## Appeal Decisions

### **Appeal A: APP/T2350/W/15/3135886**

#### **Wolfen Hall, Chipping, Preston, Lancashire PR3 2NZ**

### **Appeal B: APP/T2350/Y/15/3135889**

4343 - 03 AB.

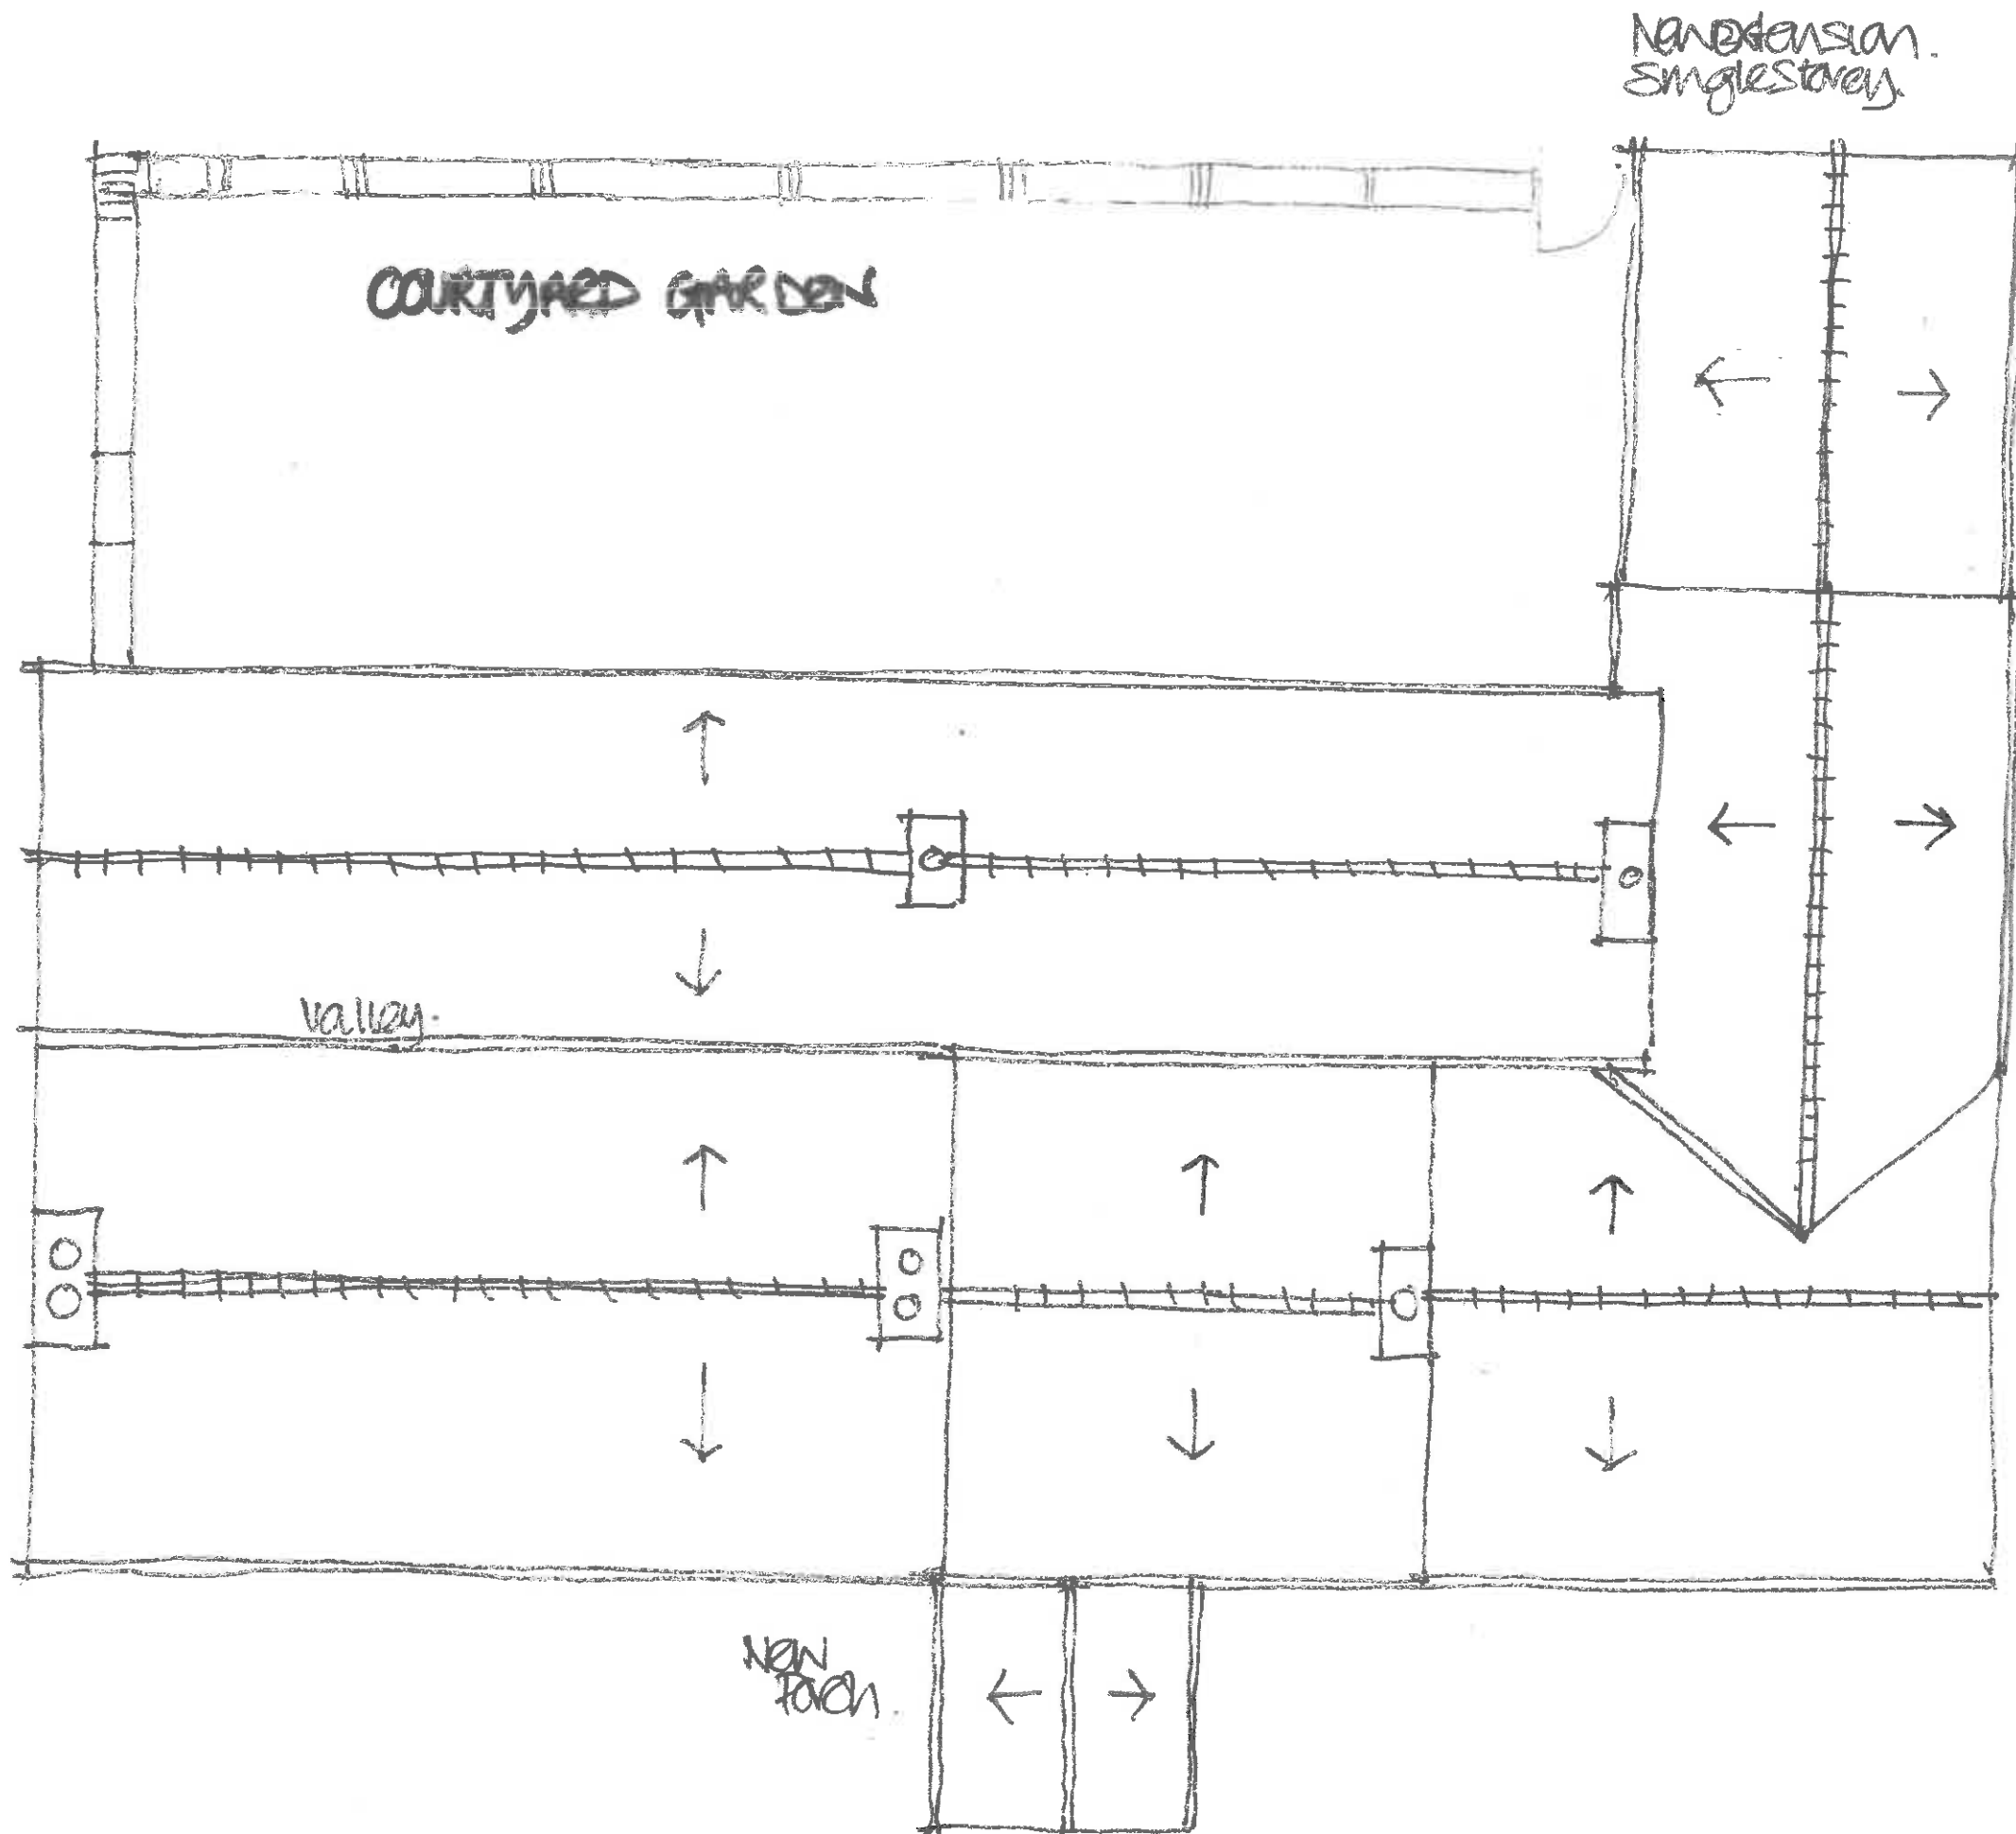
3. Drawing 4343-06A does not show a proposed doorway on the rear elevation where a window is currently situated. As the doorway is shown on drawing
-

4343-03AB as well as drawing 4343-09A I am satisfied that this is the result of a drafting error. I have determined the appeal on this basis.

MR & MRS. L. MORRIS
WOLFEN HALL
CHIPPING
PROPOSED VIEW
OF EXTENSION +
WALLED GARDEN!
NTS. 4343.09A.

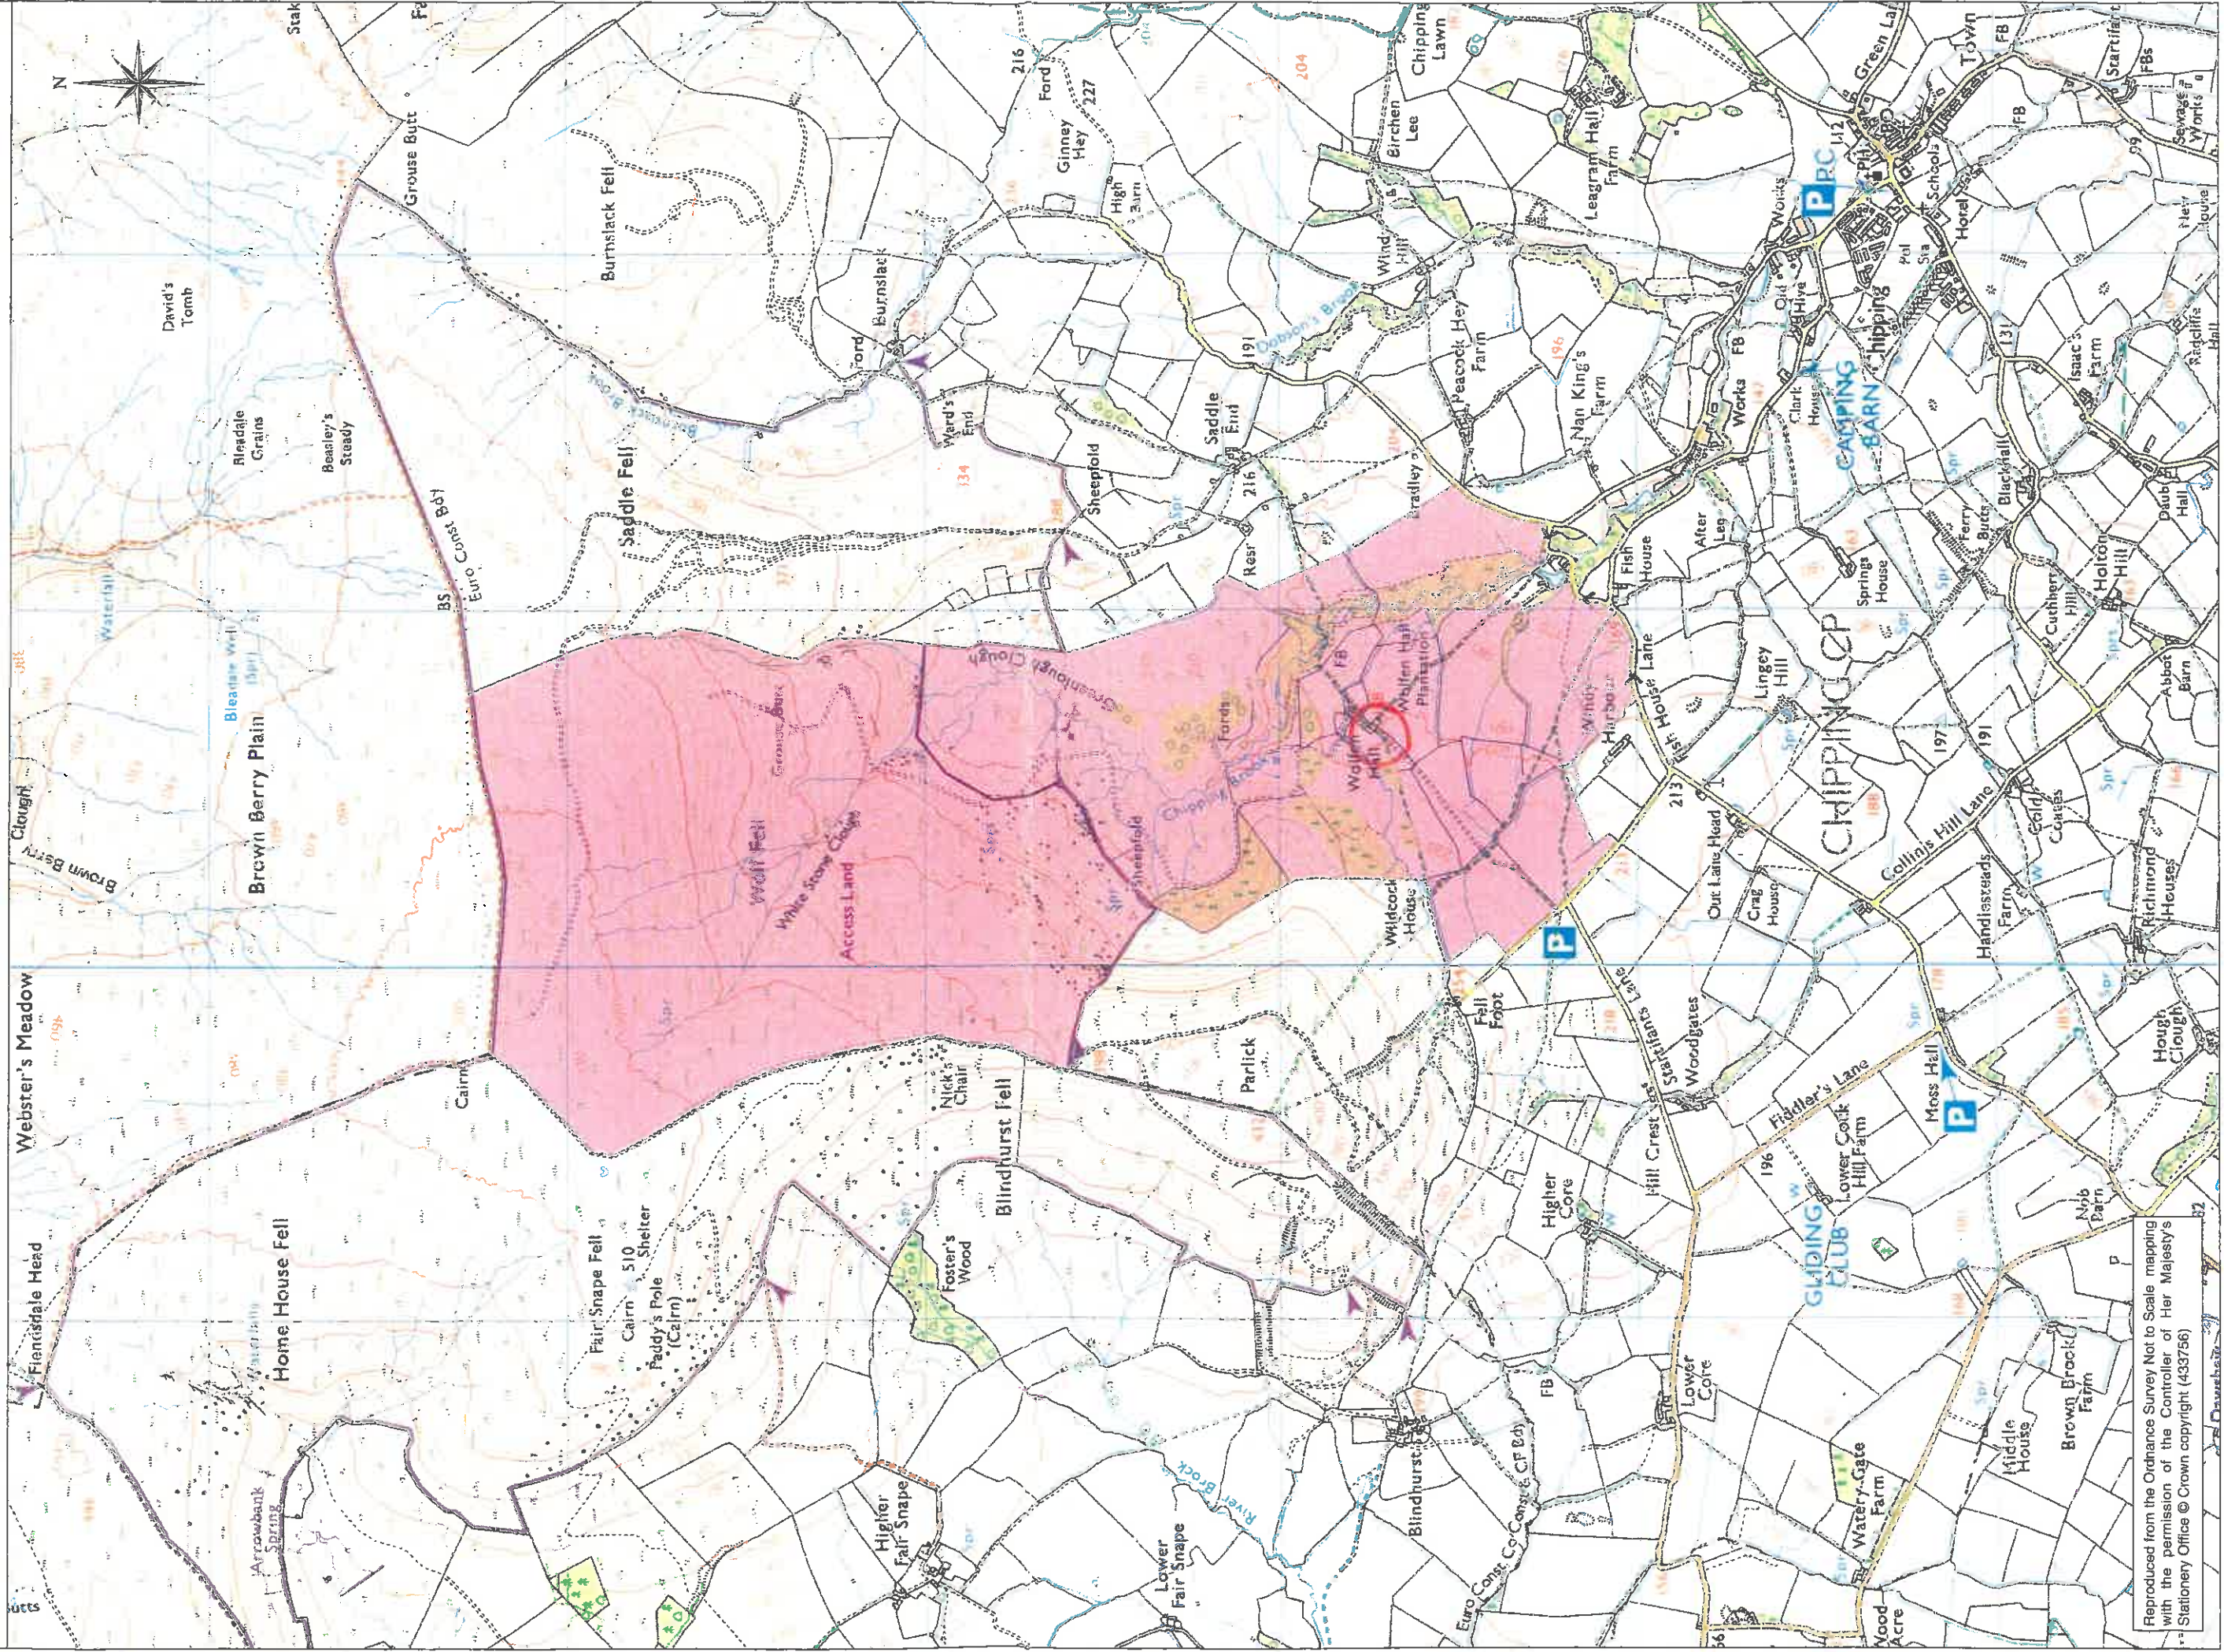
11. I accept that the lower part of the rear elevation would be obscured by the proposed 1.8m enclosure and that its height would lead to an over-dominant boundary feature. However, this impact could be mitigated by reducing the height of the wall through the use of a suitable condition that reflects the character of stone walls in the wider landscape which the Council have suggested is around 1.4m. If a lower wall were present I am satisfied that it would not dominate the rear elevation. This would ensure that the linear form of the dwelling and legibility of the different phases of its development remain clearly apparent. Moreover, the combined footprint of the house and garden would retain a rectangular footprint when viewed as a distant feature in the wider landscape thus preserving this particular cultural dimension of the AONB.

- 1) The development hereby permitted shall begin not later than 3 years from the date of this decision.
- 2) The development hereby permitted shall be carried out in accordance with the following approved plans: 4343-03AB, 4343-04, 4343-07, 4343-09A.
- 3) Notwithstanding condition 2, the enclosing garden wall shall not exceed a height of 1.4m in perpetuity.
- 4) No development shall take place until details of the proposed changes to the north elevation of the dwelling have been submitted to and approved in writing by the local planning authority. Development shall be carried out in accordance with the approved details.
